# ***City of Albuquerque***

**RE: ENGINEER'S CERTIFICATION FOR TRAILS WEST SUBDIVISION (B-13/D6C)  
RECEIVED DECEMBER 18, 1995 FOR FINANCIAL GUARANTY RELEASE  
ENGINEER'S STAMP DATED 12/14/95**

TITLE:
TRAILS WEST SUBDIVISION
GRADING AND DRAINAGE PLAN

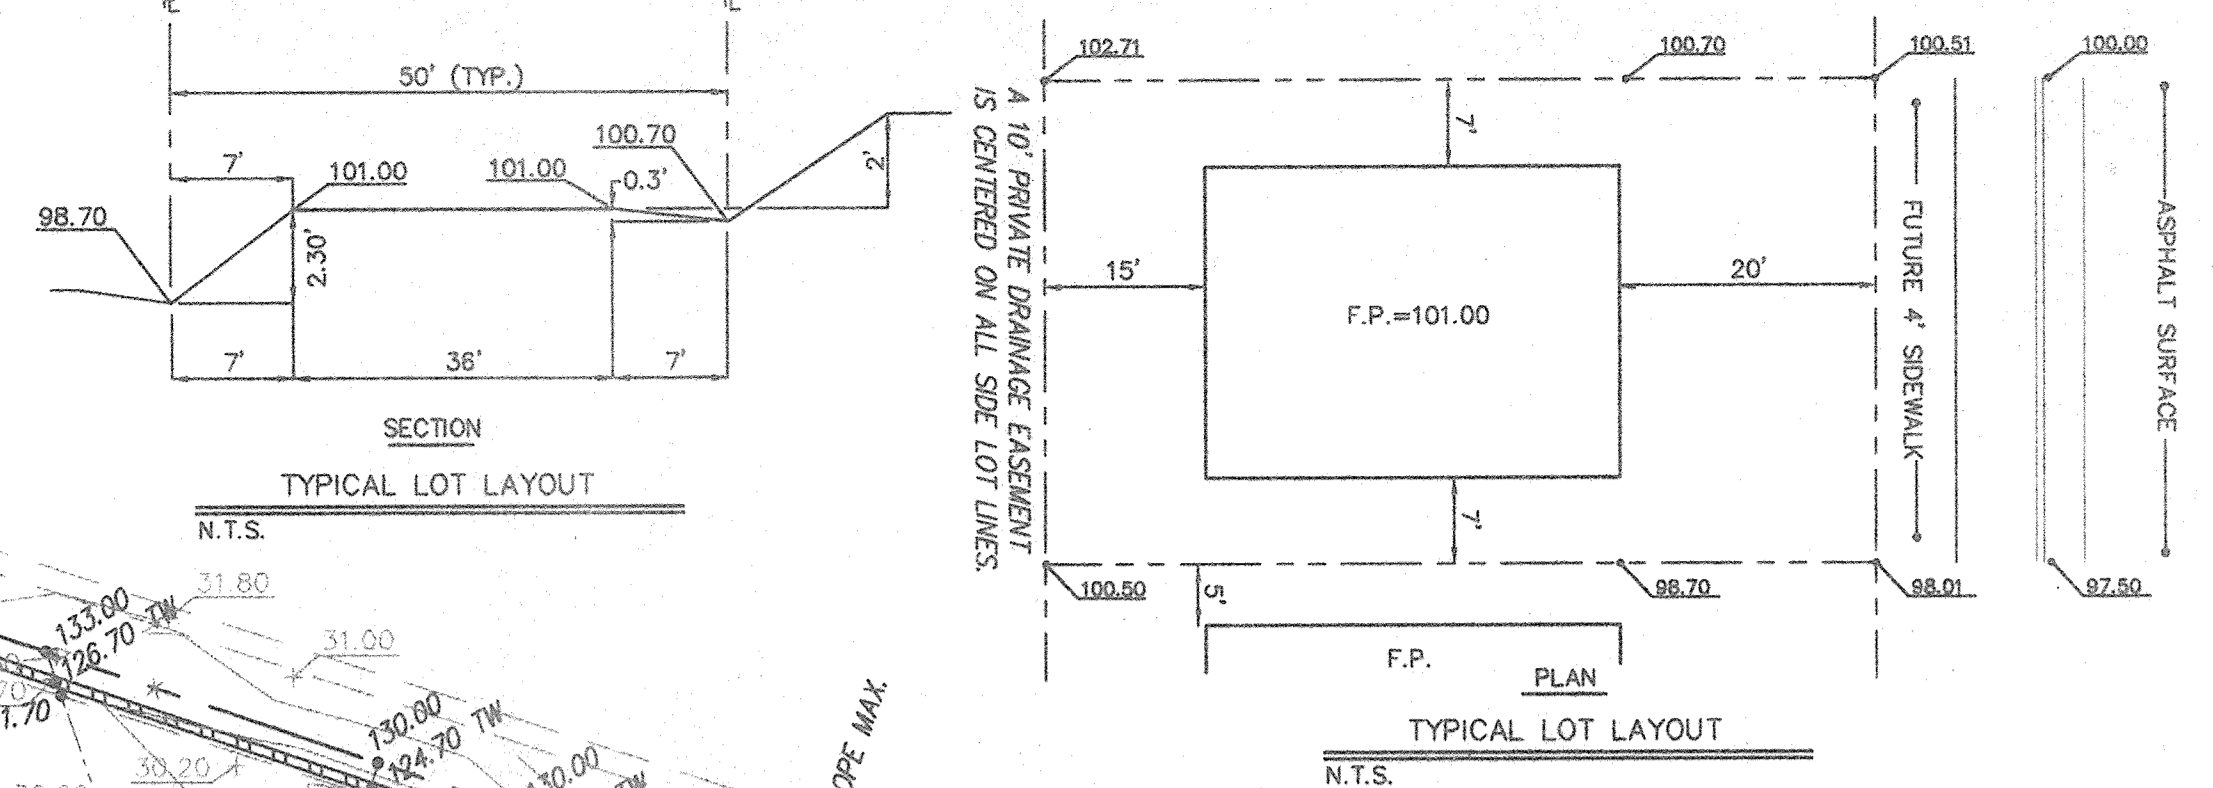
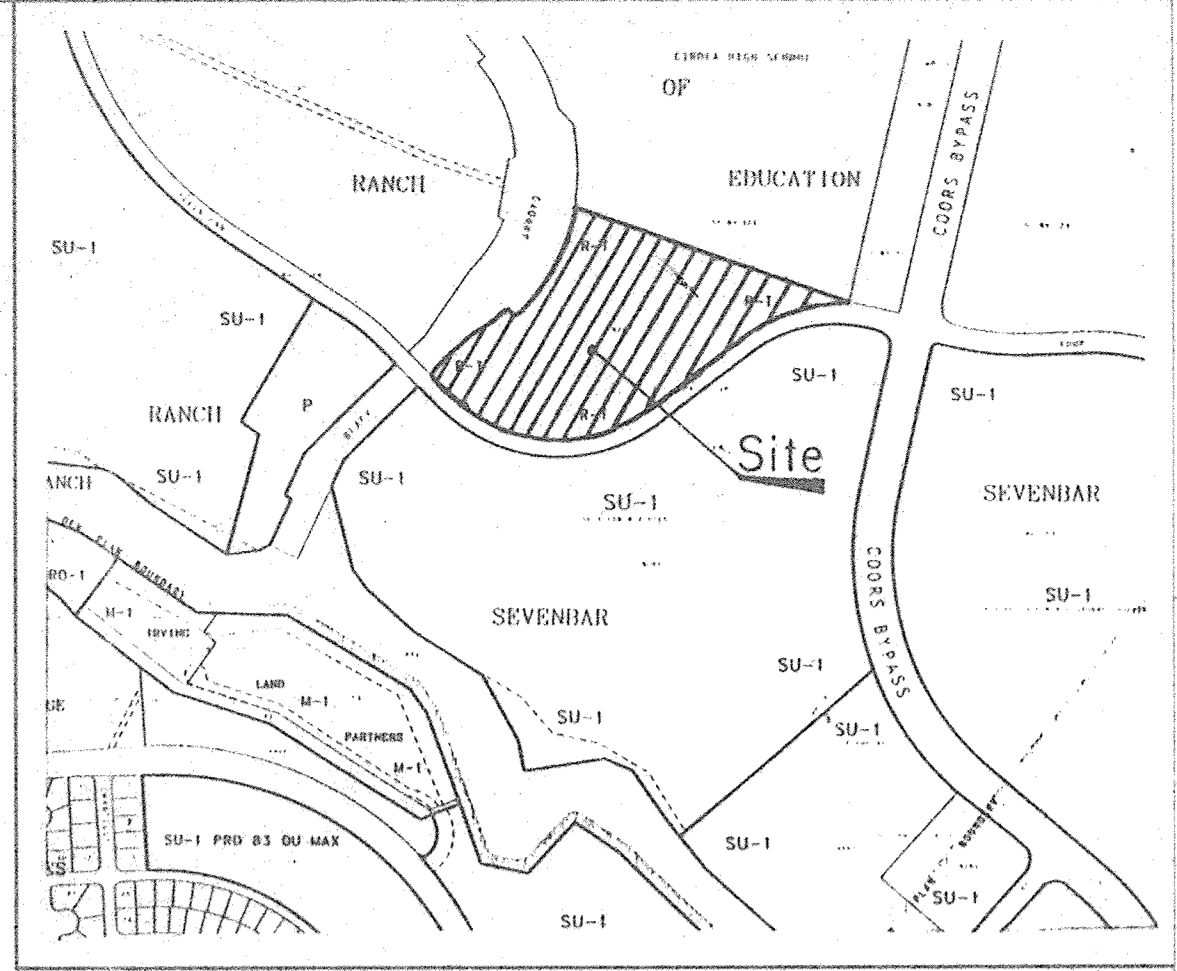
**City Hydrology requires as-built elevations for every pad or FF. As-built elevations are also required at every other corner of each lot. Top of curb elevations may be used on the street side of the lot. This is the minimum as-built elevation requirement.**
